**Consultation Response from KC, Conservation & Design****2024/90758 and 2024/90759 - White Syke Farm, Marsden Lane, Marsden, Huddersfield, HD7 6AF****Renovation of outbuilding and erection of glazed lean-to on the south east elevation of the outbuilding to form domestic workshop for uses incidental to the enjoyment of the dwellinghouse (Listed Building)****Listed Building Consent for renovation of outbuilding and erection of glazed lean-to on the south east elevation of the outbuilding to form domestic workshop for uses incidental to the enjoyment of the dwellinghouse****Date Responded: 30.04.2024****Responding Officer: S Pickles****Responding Ref:**

Drawing Title:
 Proposed Ground Floor Plan and
 Roof Plan

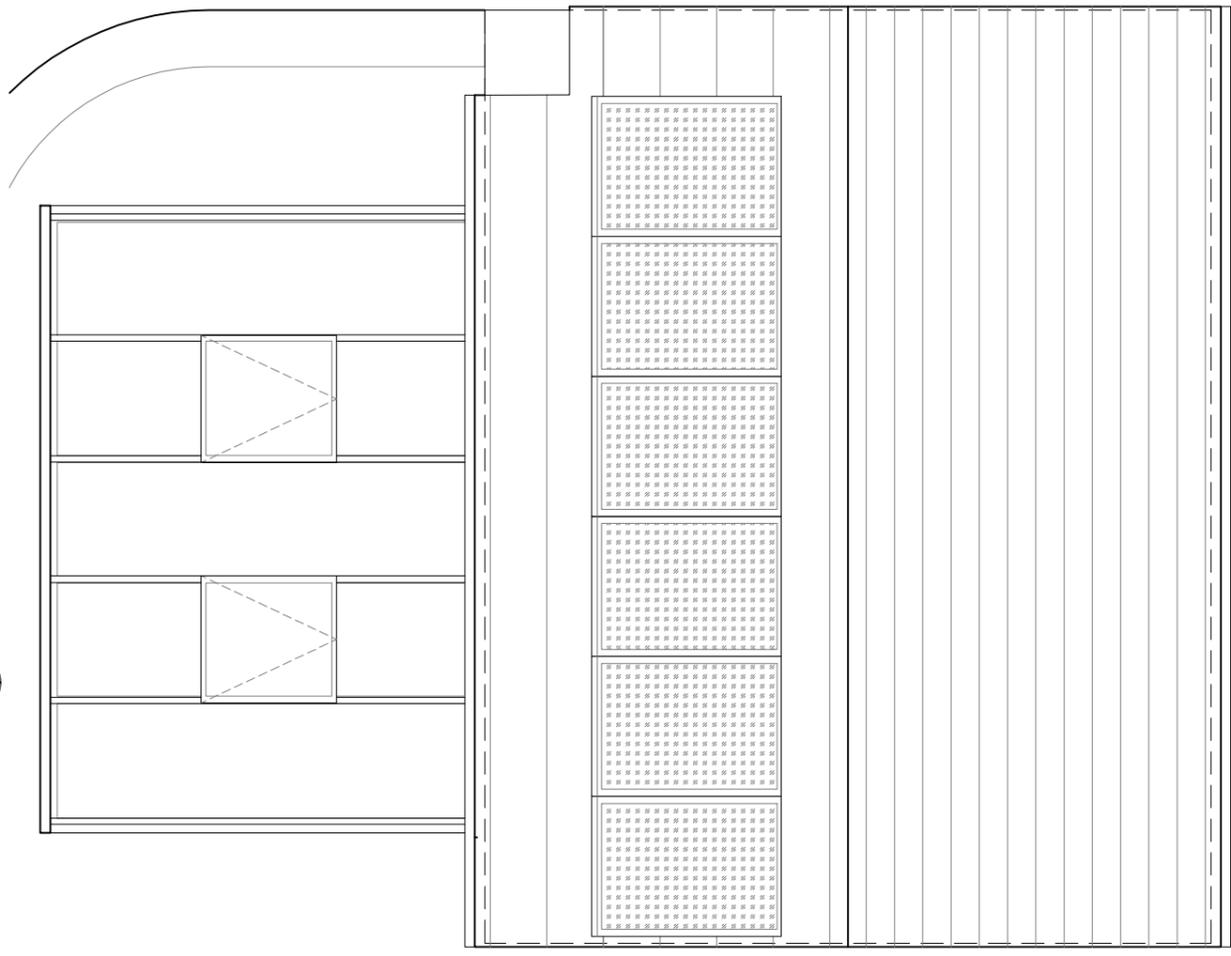
The statement sets out that the floor is to be removed, a DPM fitted and PIV insulation applied and a new screed. We would not support this approach as it would be applying materials which are impermeable and would conflict with the construction of the building. We consider that it would be required for the materials for the floor to be conditioned to be limecrete and make no use of a DPM.

The existing windows are noted as being removed and replaced with aluminium frames. While we could support the replacement of the existing windows, we would not support the use of aluminium frames as these would conflict with the character of the building, appearing overly thick and chunky and not able to replicate the detail of timber. We consider that replacement windows should be constructed of timber and further joinery details should be provided for each window type.

The existing sliding door to the northern elevation is shown as being retained, which we are supportive of as this will retain the character of the building, however, the plans show a glazed screen fitted to the outside of the door, which is indicated as being aluminium framed. We appreciate the reason behind

doing this, however as stated we do not support the use of aluminium frames, as this would appear overly thick and create a negative detail and this is illustrated by the elevation plans.

We consider a glazed screen could be acceptable, however, we would need the frame to be reduced, so that it appears as if this is frameless, and the screen needs to be set further back into the reveal so that the depth is retained as much as possible. Sketch plan below for reference.

To the southern roof plane, it is proposed to a row of 6 PV panels. Further detail is required for the proposed method of fitting for the panels. The position of the panels will mean they are less visible, but will be visible when with the site, however, we need to be satisfied that with the method of fitting, they will sit as close to the roof plane as possible. Additionally, detail needs to be provided on whether the PV panels will feed directly into the mains of the building/ house or if they will have battery storage.

The final element is the proposed extension to the southern elevation, which is detailed as being a modern interpretation of a greenhouse. Conservation is not fully convinced by the element of the proposals and the main concerns are not only the impact, but the materials and design. As shown on the plan, it does not take up the full length of the elevation, but it has been inset. However, the plans show a very thick squared frame. We consider that a more traditional style building needs to be considered. If the extension is to be purely a greenhouse, as stated in the plans and the supporting statement, then a traditional-style greenhouse should be considered. This would have a small stone, possibly a brick base/ plinth and upper timber lean-to, which would include opening windows with the roof for ventilation. This would be of a more appropriate construction and finish than what is currently proposed in the plans.
